**SITE PLAN CONTROL APPLICATION
DELEGATED AUTHORITY REPORT
MANAGER, DEVELOPMENT REVIEW, CENTRAL**

Site Location: 258 Carruthers Avenue

File No.: D07-12-18-0163

This SITE PLAN CONTROL application submitted by Eugen Mihaescu, Robertson Martin Architects, on behalf of 258 Carruthers Ltd., is APPROVED as shown on the following plan(s):

4 West Elevation  
A-04 SCALE: 1:100

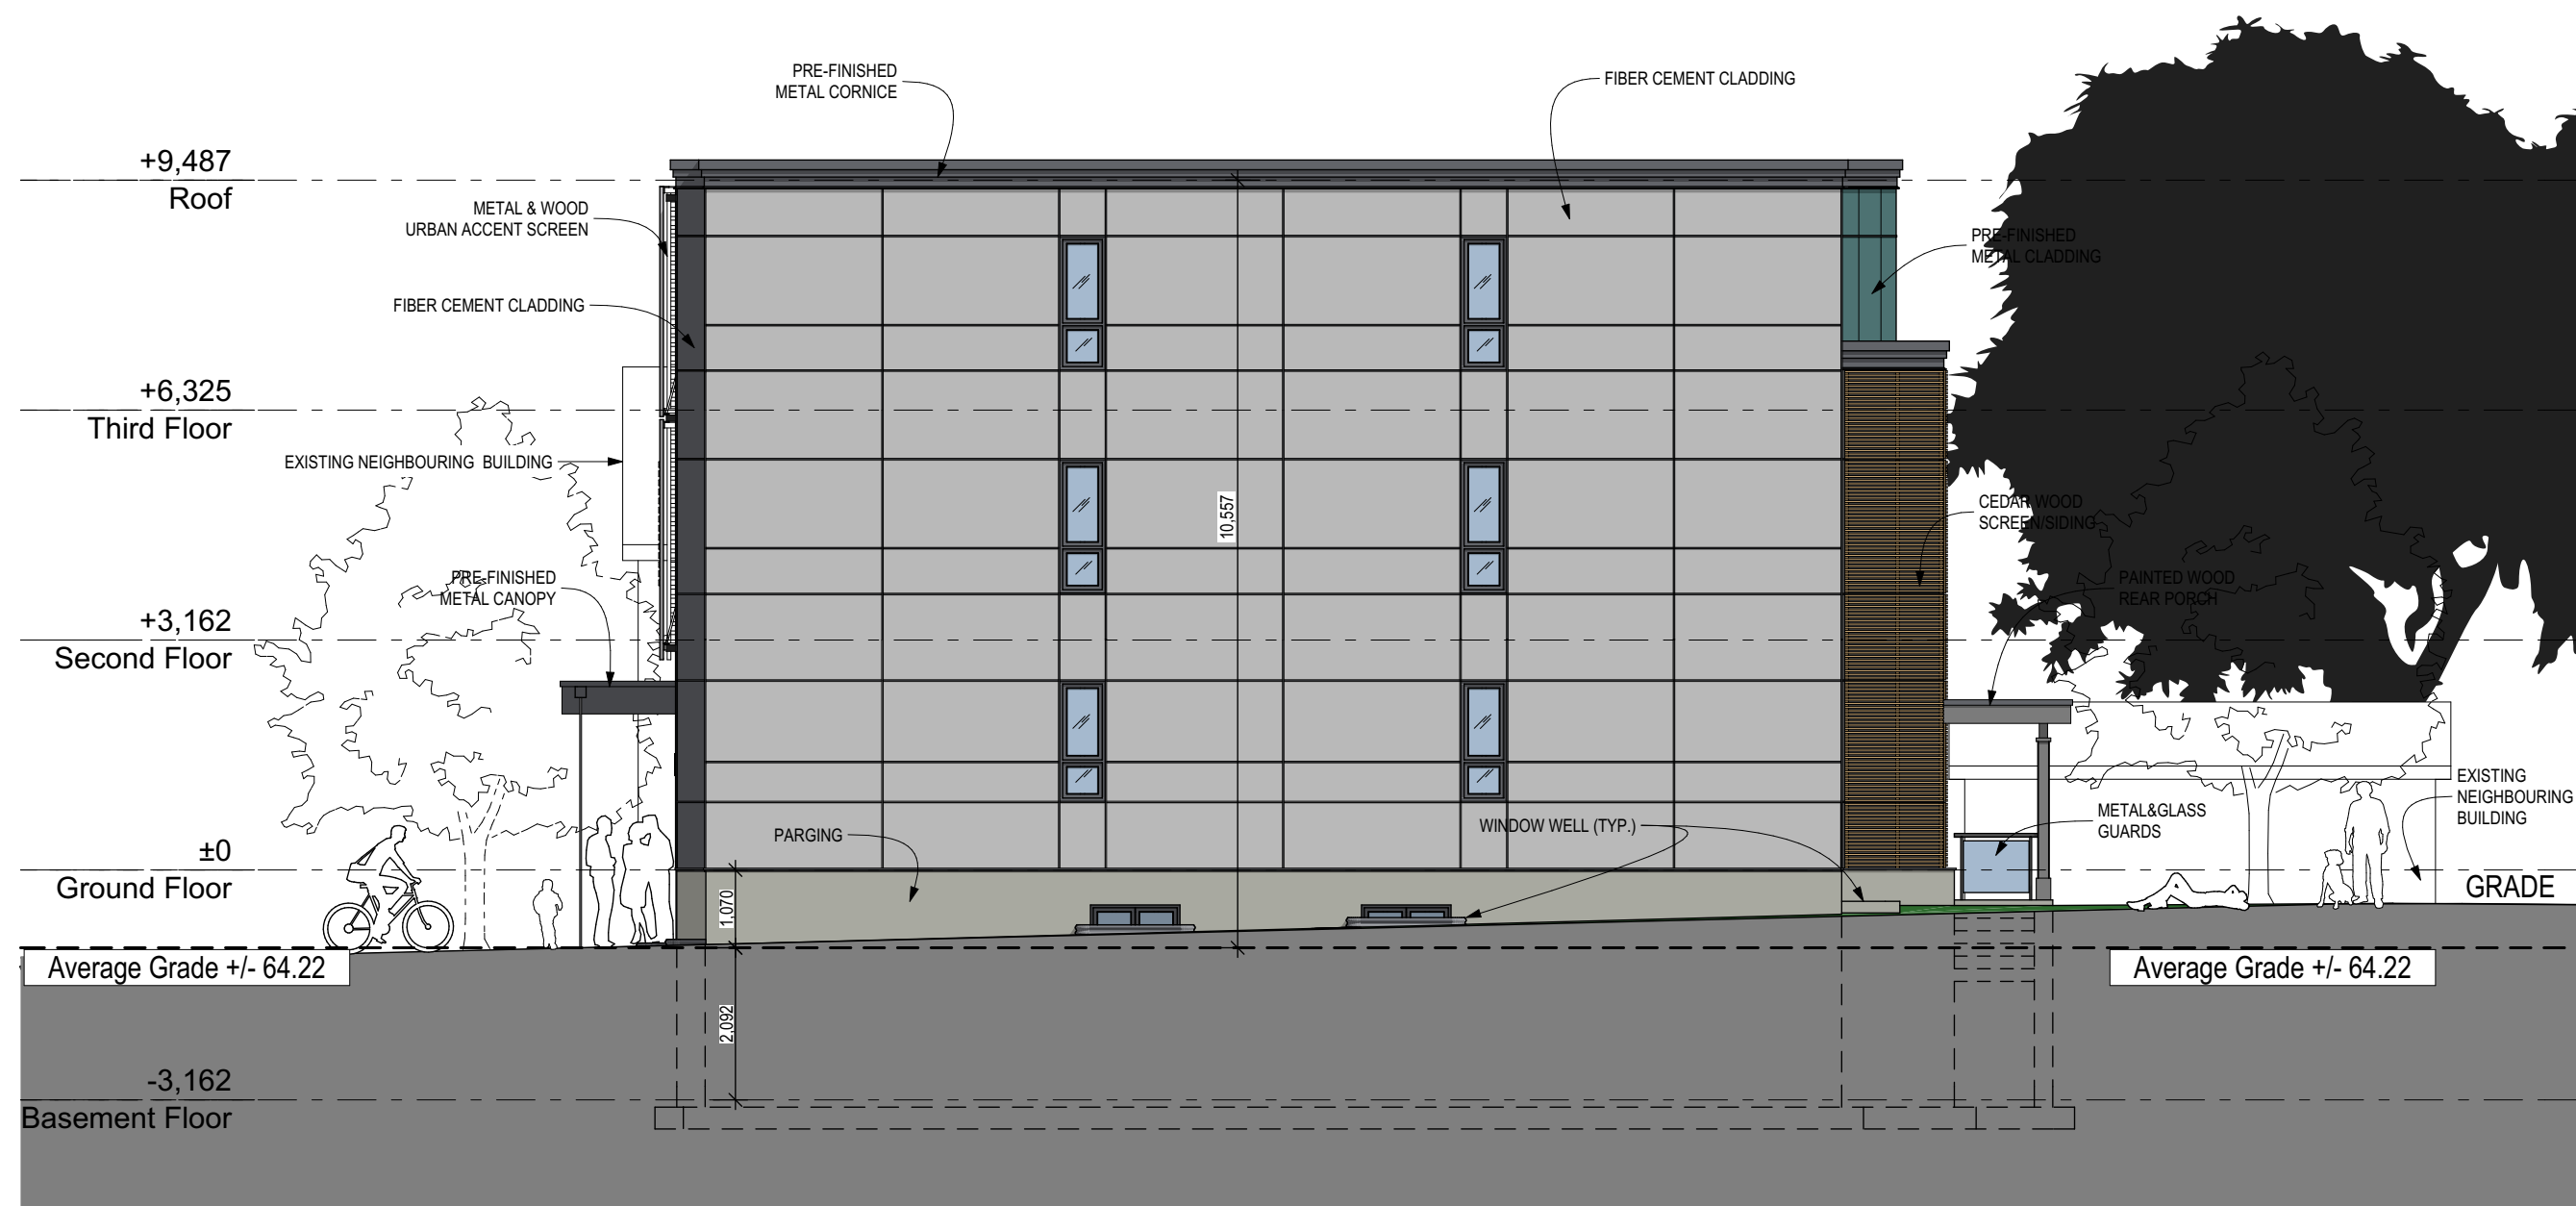
Balconies in the rear will create privacy issues for adjacent lots.

One suggestion is to eliminate the balconies in the rear and put balconies on the front of the building to create a better relationship to the street and to allow for better interaction with the surrounding community.

Balconies in the rear have been removed and Juliet balconies have been added to the front and rear of the building.

1
A-01
Site/Landscape Plan
SCALE = 1:75

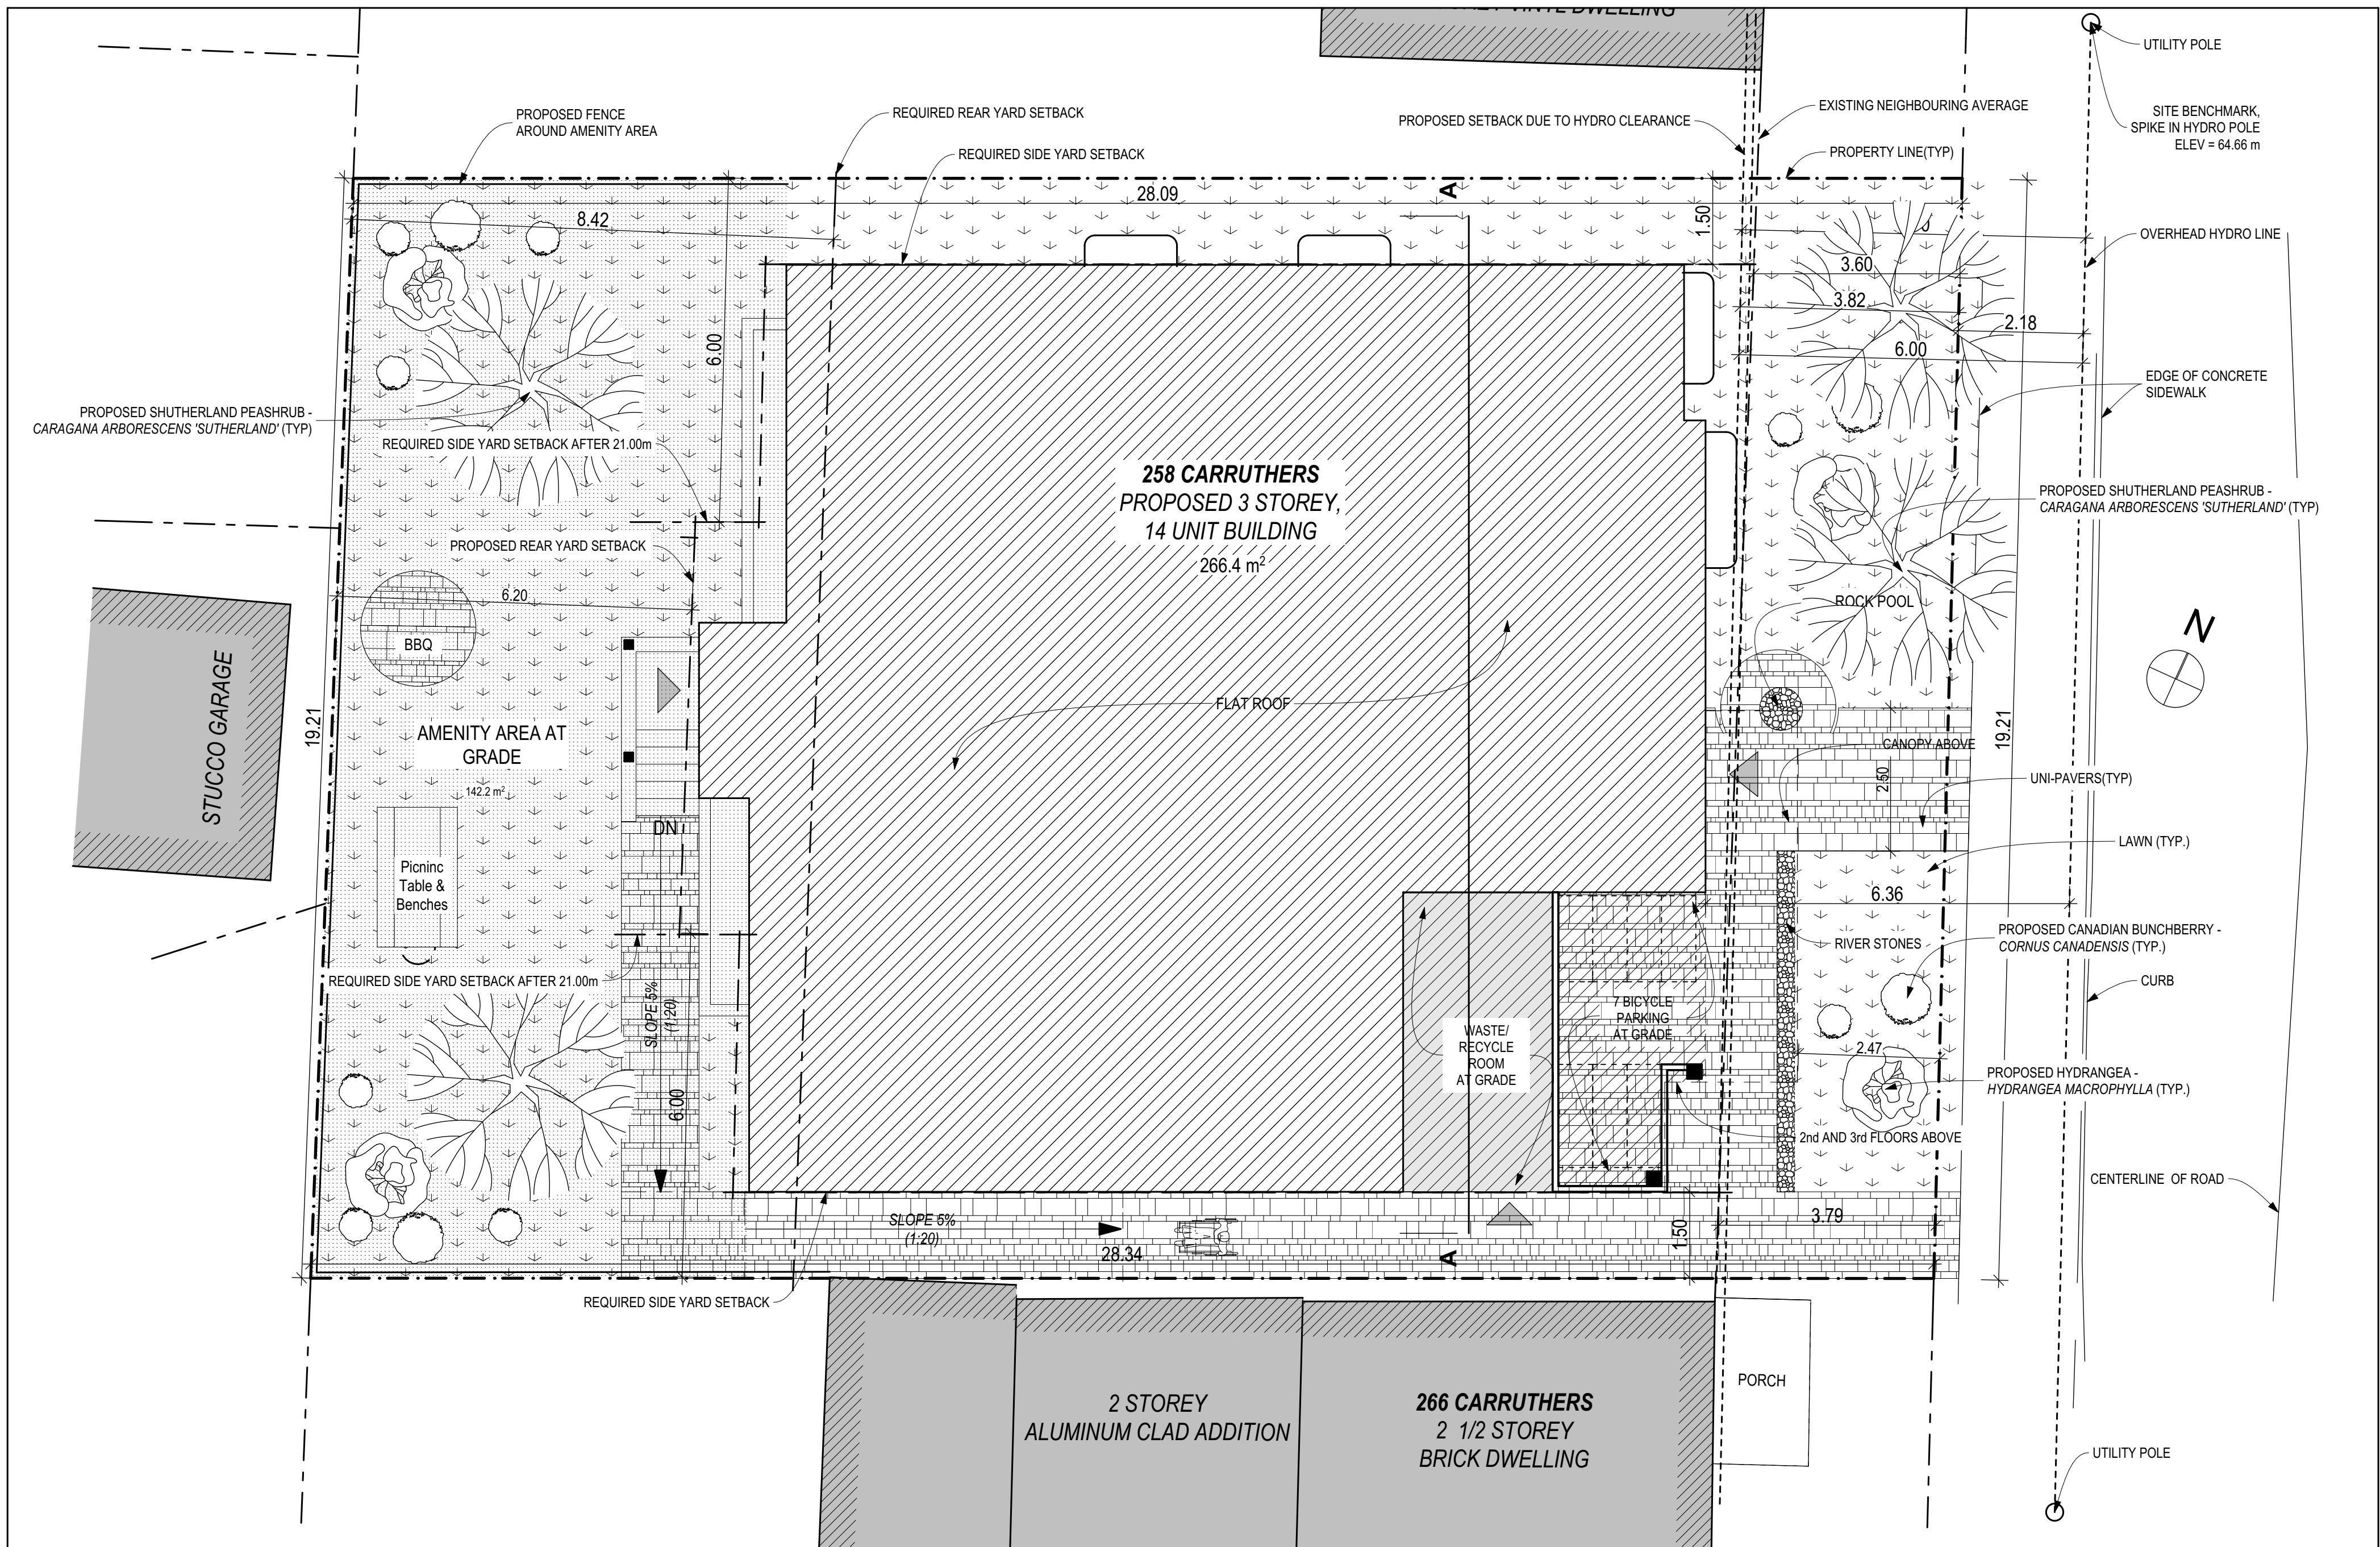
Is there going to be a fence constructed along the rear lot line?

Plant street trees/trees in the front yard.

A fence is to be installed along the rear property line.

Additional landscaping, including additional trees, have been added in the front yard. Trees are also proposed to be planted in the rear yard, and over 50% of the lot is soft landscaping.
